**A38 Derby Junctions**  
**TR010022**  
**8.16 (Draft) Statement of Common**  
**Ground with**  
**Euro Garages Ltd**

**Statement of Common Ground**  
**Euro Garages Ltd**

**This Statement of Common Ground has been prepared and agreed by (1) Highways England Company Limited and (2) and Euro Garages Ltd.**

Drawing Title  
FIGURE 2.6  
MARKEATON JUNCTION  
GENERAL ARRANGEMENT

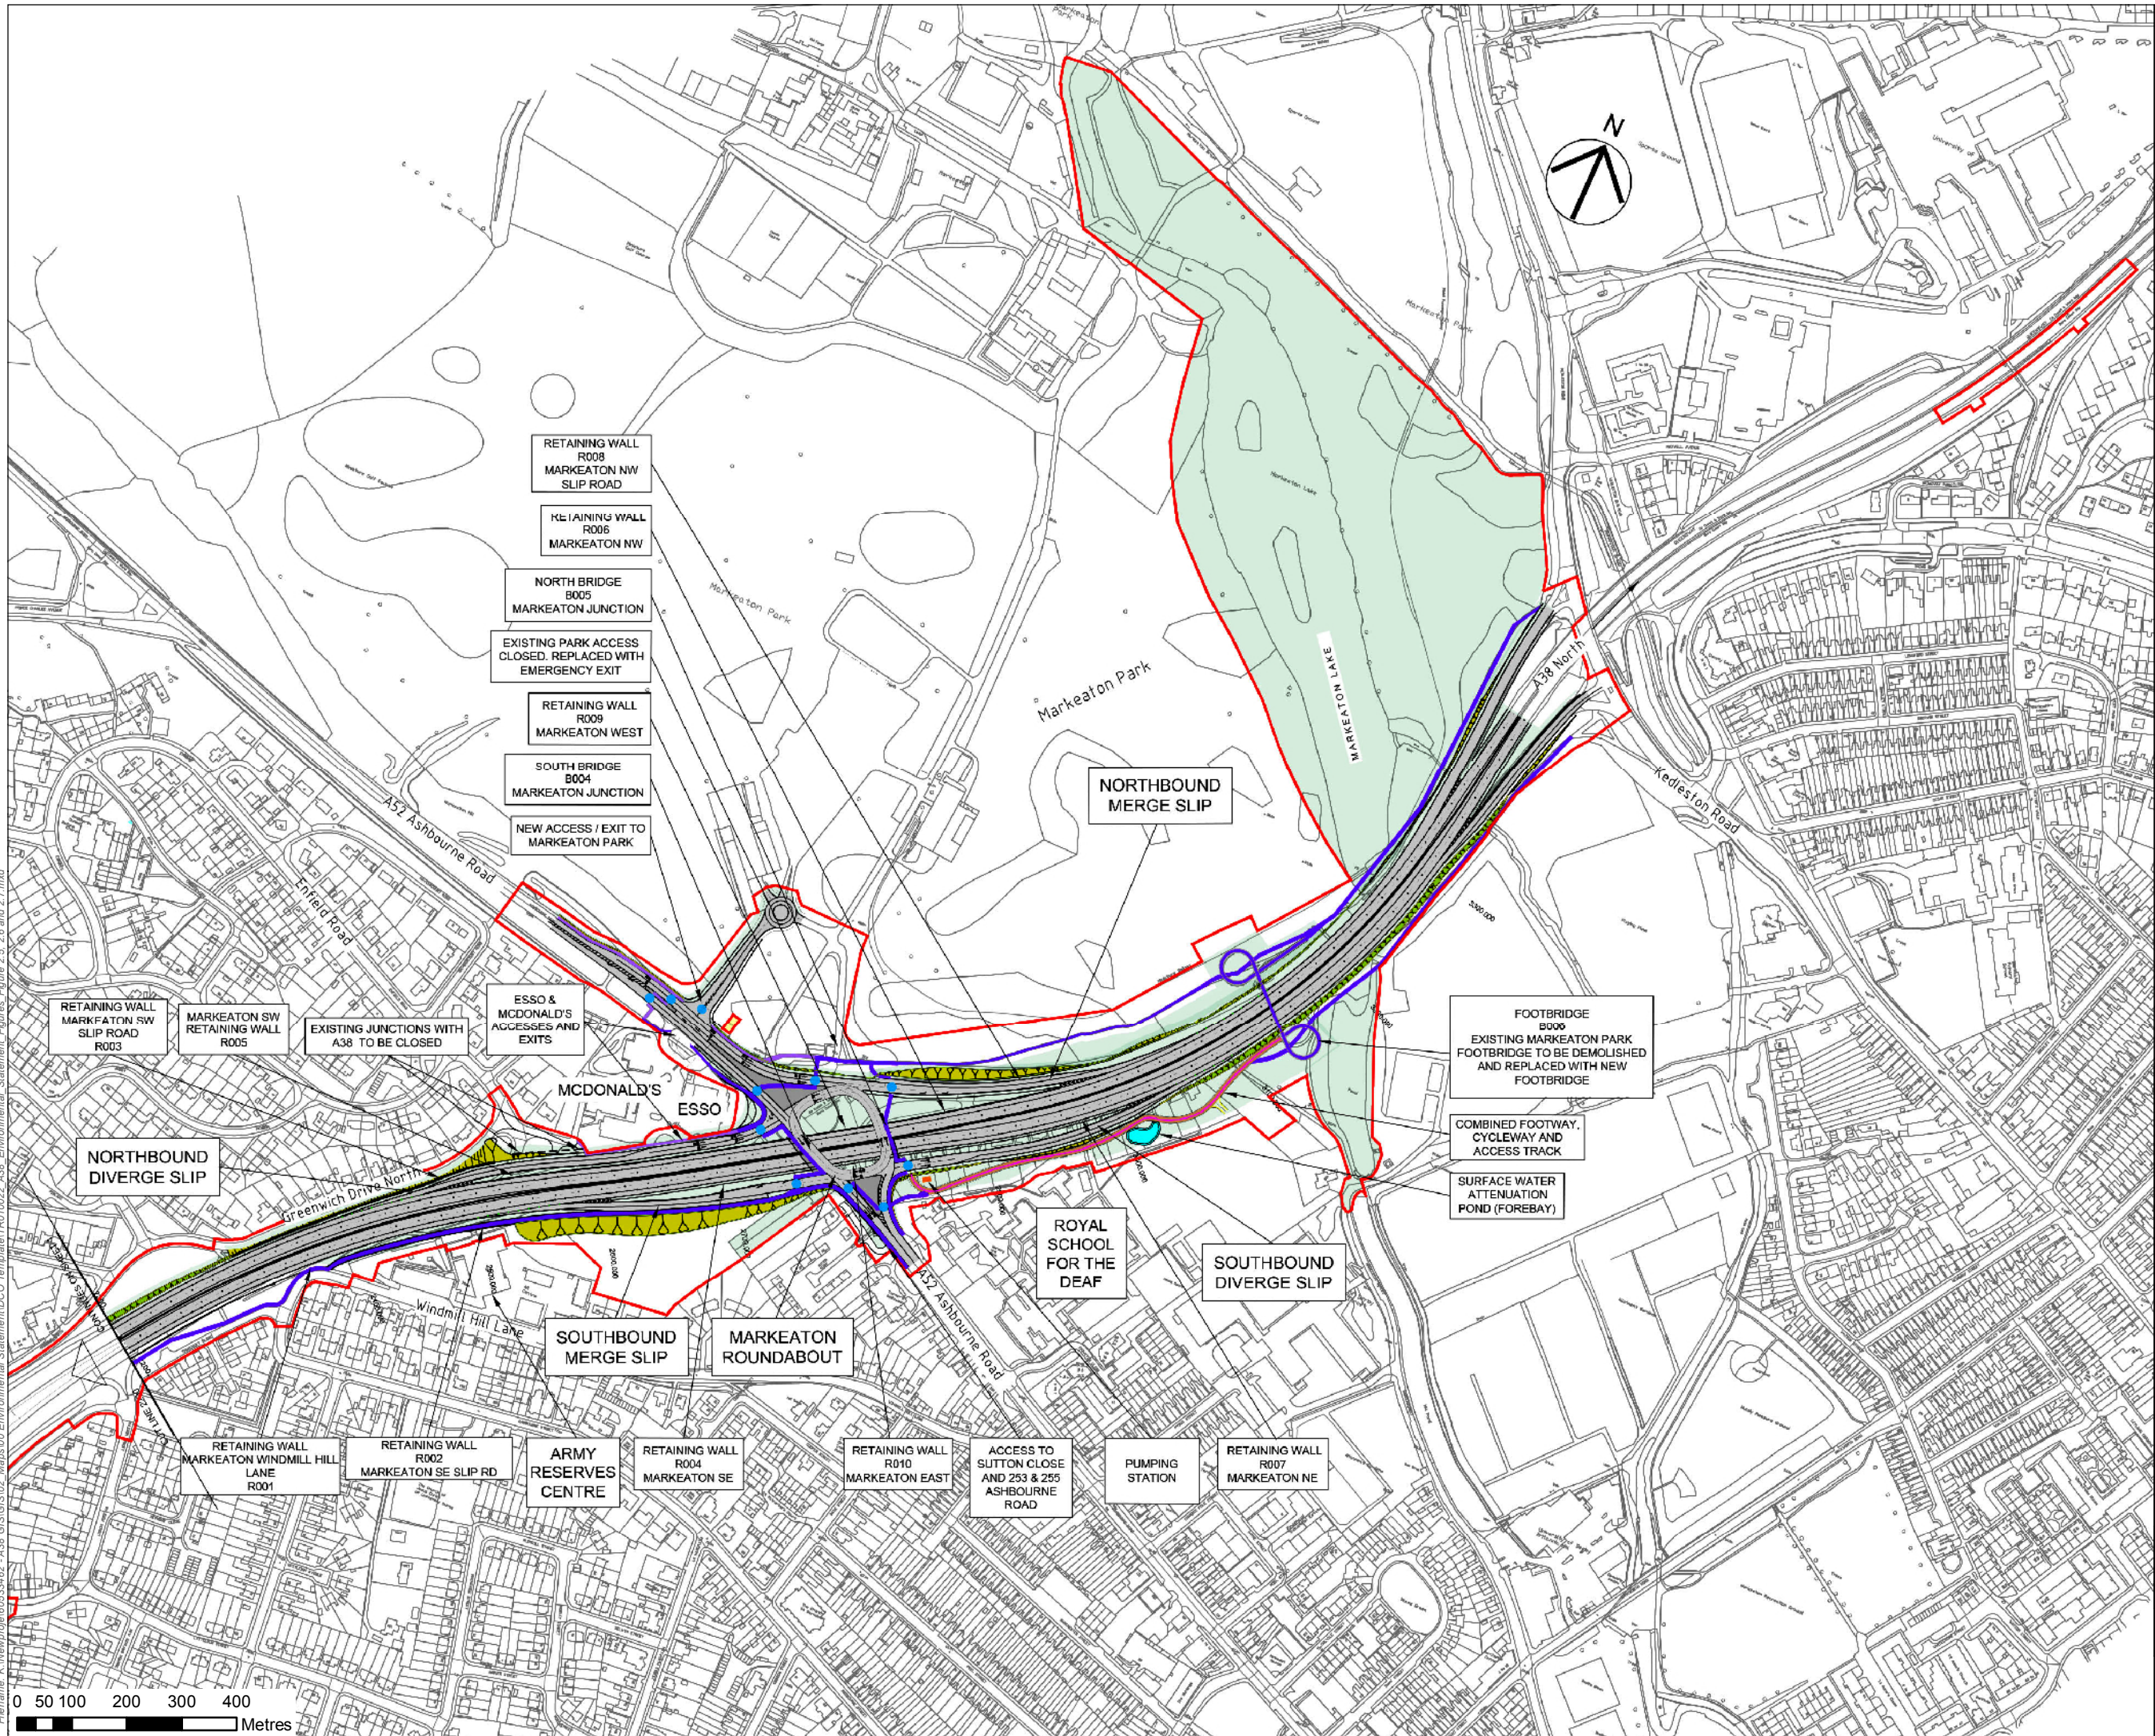
Issue reference (see Appendix A)	Document	Paragraph Ref	Sub-section	Comment	Highways England Response	Status
Issue ref: n/a	Written Representation Comments	-	-	Euro Garages Ltd does not object to the principle of the Scheme.	Noted.	Agreed.
Issue ref: I.1, access and economic impact	Written Representation Comments	-	-	As readily accessible facilities [the service station], passing motorists can visit them without the need to depart from the strategic road network towards the town centre in search of services. The proposed scheme will have a serious and adverse effect on the trading operation of the service station. Petrol filling stations are trade related properties and trading performance is directly affected by certain key factors including accessibility and prominence to substantial traffic flows. The effect of the Scheme will be to allow traffic on the A38 to freely flow underneath the junction. This critical source of north and southbound trade will be lost to the service station, although this	<p>Euro Garages' concerns regarding the potential loss of trade is noted.</p> <p>Highways England is currently investigating how/whether the combined site (Euro Garages and McDonald's) can be designated as a Trunk Road Service Area (TRSA). TRSAs can be signed as 'services' directly from the Trunk Road network.</p> <p>At the meeting of 15<sup>th</sup> of Jan 2020 it was agreed that Euro Garages and McDonald's would provide safety case for provision of signage; HE will</p>	Under discussion

Issue ref: I.1, access and	Written Representation Comments	-	-	Additionally, Euro Garages Ltd property currently enjoys direct and satisfactory access to the public highways of both the A38	Currently it is necessary to cross land owned by McDonald's to gain access to the filling station from both the A38 and the A52.	Agreed

Issue reference (see Appendix A)	Document	Paragraph Ref	Sub-section	Comment	Highways England Response	Status
economic impact				and A52 without the need to cross land in third party ownership. Unless the orders make provision for continued direct and satisfactory accesses that would allow the effective use of the service station in commercial terms, Euro Garages Ltd property would be further and unnecessarily depreciated in value.	<p>A check with the land registry confirms that there are appropriate rights, by way of a conveyance dated 1982 to allow those who need to access the filling station to cross the land owned by McDonald's which abuts the highway at any time, day or night.</p> <p>The Scheme will not change these existing arrangements.</p> <p>At the meeting of 15<sup>th</sup> of Jan 2020, Highways England provided a plan to demonstrate that EG and their customers can enter their facility without going outside any land that is either in EG or McDonald's ownership but has existing rights in place to allow EG (and their customers) to pass and re-pass over or is already highway land.</p>

Issue reference (see Appendix A)	Document	Paragraph Ref	Sub-section	Comment	Highways England Response	Status
Issue ref: I.1, access and economic impact	-	-	-	<p>The Highways England statement (as set out above), that the Scheme will not change these existing arrangements is not accepted on the basis of the preliminary investigations that have been undertaken on behalf of Euro Garages Limited.</p> <p>These investigations, which have involved producing a draft overlay plan, illustrate that the documentary rights of way referred to in Highways England's response will be interfered with as a consequence of the Scheme. Whilst the detail needs to be verified through detailed site survey to check the overlays, it appears that the Scheme (as proposed) will involve access over land lying outside the existing rights of way which is not within the control of Euro Garages Limited. If detailed investigation confirms this position, the adverse consequences on the operation</p>	See above	Agreed

Issue reference (see Appendix A)	Document	Paragraph Ref	Sub-section	Comment	Highways England Response	Status
				of the service station and the resultant depreciation in value are likely to be significant. Euro Garages Limited considers that it would be possible for Highways England to ensure that appropriate rights of way can be made available to accommodate these issues and mitigate the adverse effects of the Scheme.		
Issue ref: I.1 the assessment and mitigation of potential impacts, including in relation to access, safety and economic impact	-	-	-	EGL has ongoing concerns over the geometric standards applied to the proposed access/egress with the A52.	Highways England's position is that the arrangements are similar to the existing layout and will be usable for all future traffic. The detailed design stage will be used to refine the design in consultation with DCiC, EGL and McDonald's and the final design will be subject to a Stage 2 Road Safety Audit so safety of operation will be assured.	Under discussion

- 3.3.1 In regard to the Scheme, EG needs to reserve the right to reserve further matters that become apparent as more detailed aspects of the design emerge (Issues ref: I.2). Given however that EG does not object to the principle of the Scheme, the key points are likely to remain advance warning signs; modifications to rights of way to allow legal post scheme operation and mitigate compensation and detailed modification to design and layout of a relatively minor nature including on-site signage, kerb alignments and surface treatments that are likely to have disproportionate benefit in the post-scheme forecourt operation.

Issue reference (see Appendix A)	Document	Paragraph Ref	Sub-section	Comment	Highways England Response	Status
				loss would be partially mitigated if advanced warning signs were provided as part of the scheme. Highways England has yet to determine whether such signage could be provided.	then seek to progress within their relevant department.	
Issue ref: I.1, access and safety	Written Representation Comments	-	-	The scheme will also seriously reduce the accessibility to the site for traffic that continues to use the junction through interference with existing access arrangements, including works of stopping up and modification of accesses. We have further concerns over the Scheme in relation to the access arrangements that are currently proposed within the Scheme, in substitution of the existing access arrangements, because of their adverse effect on essential safe fuel delivery arrangements and access for HGV traffic.	The site will continue to enjoy entry and exit arrangements with the A52. The existing entry and exit arrangements with the A38 are to be modified to exit only (onto the proposed A38 slip road) for safety reasons.  It is envisaged that fuel delivery will continue as it does at present, i.e. the tanker will enter the site from the A52 and will leave the site onto the A38 slip road.	Agreed
